SECTION 75W MODIFICATION No. 8

PROJECT APPROVAL MP 06_0258

CASUARINA TOWN CENTRE

ADDENDUM REPORT 16 December 2014

1 NORTH ELEVATION
A003 1: 200

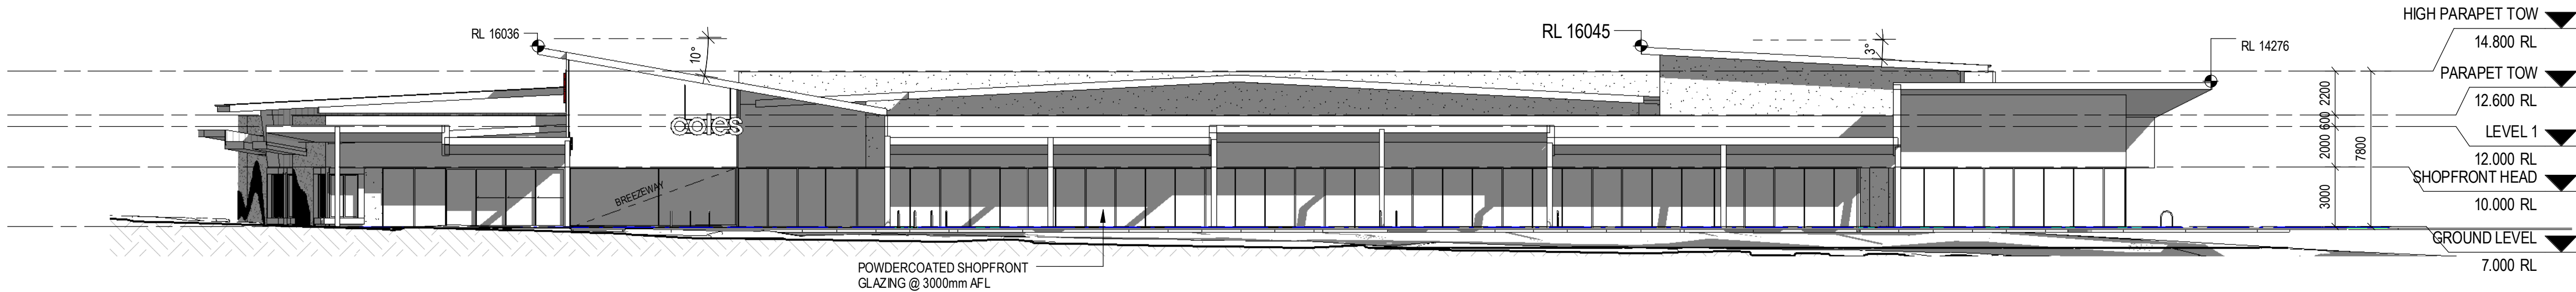
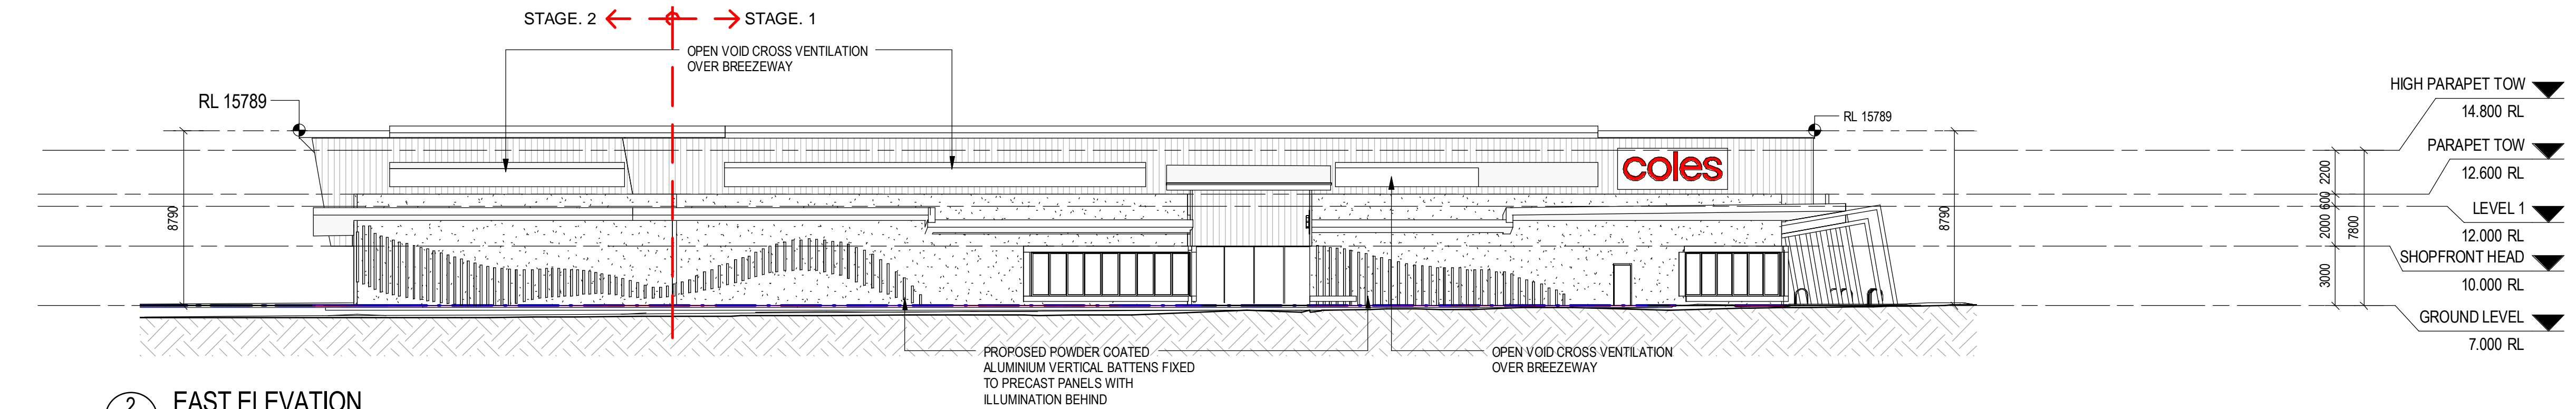
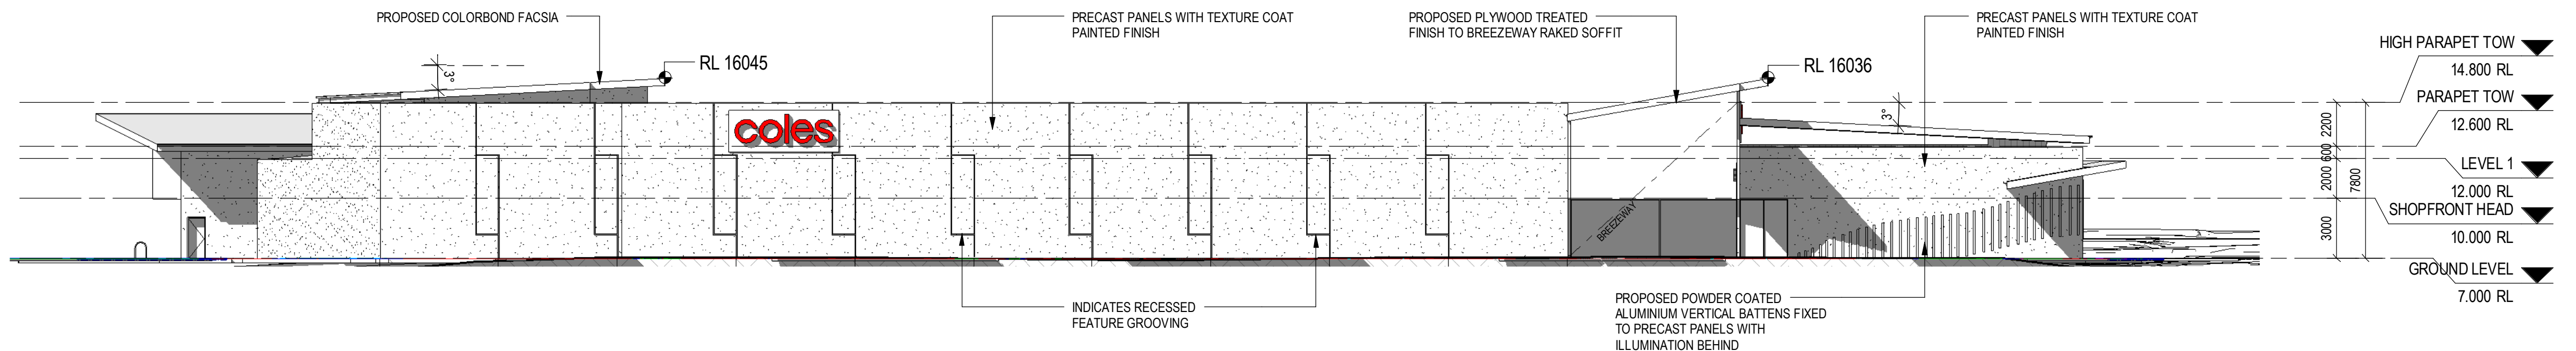
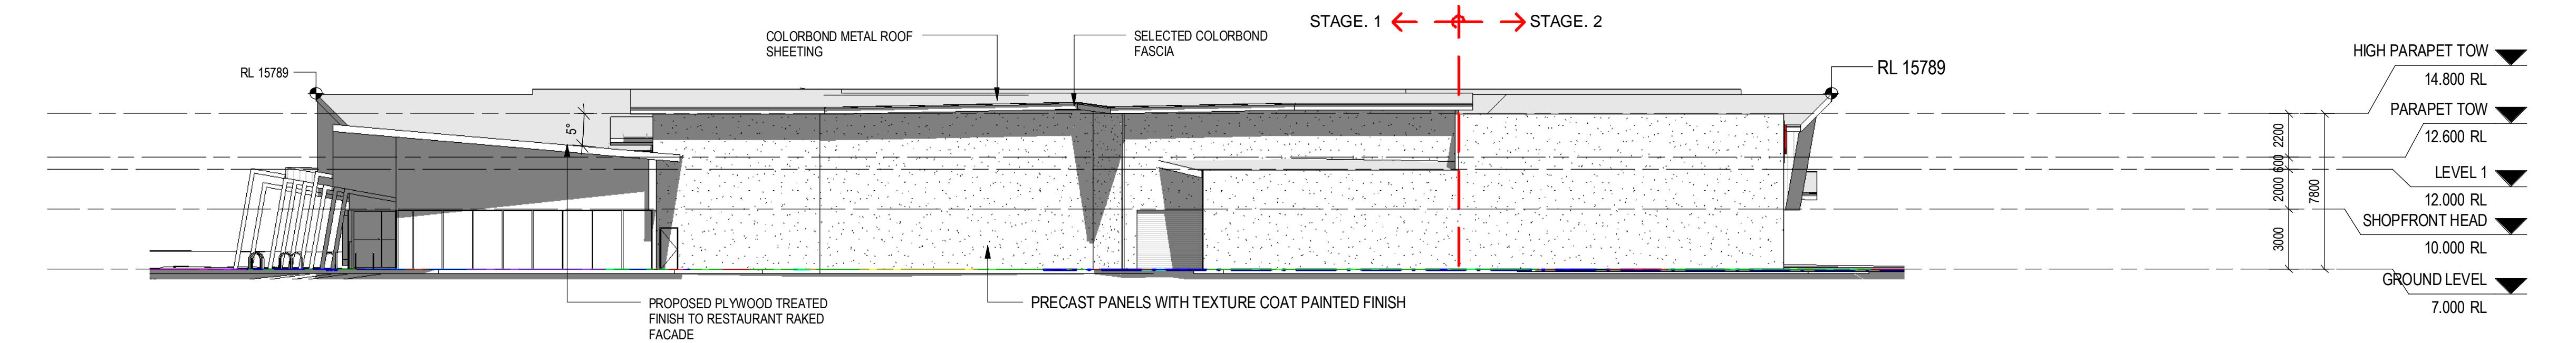
The EAR of August 2014 states that "the overall bulk of the building is reduced through principal changes of lowering the ridge height, reducing the height of facades...". This is not correct.

The Mod 8 drawings indicate a slight increase in overall building height over the approved drawings. These include:

- An increase in the ridge height from RL 14013 to RL 14.800;
- An increase in the maximum building height from RL 15730 (at the office/ plant room) to RL 16036 (breezeway feature roof);
- An increase in the parapet height from of RL 14100 to parapet height of RL 14800.

These changes are considered inconsequential given the greater articulation in the façade and roof forms and a more detailed and careful resolution of design and form incorporated into the modification. These design improvements results in a building with façade and roof elements that have a more appropriate and harmonious scale. The apparent bulk of the building is reduced compared with the approved scheme whilst the mass of the development in terms of floor space and general height remains the same. The greater articulation of the building facade and roof provides a range of scales and entries appropriate for the town centre environment.

The greater finesse to the design results in an improved urban design and architectural outcome whereby the minor increase in height of elements would not be perceived.
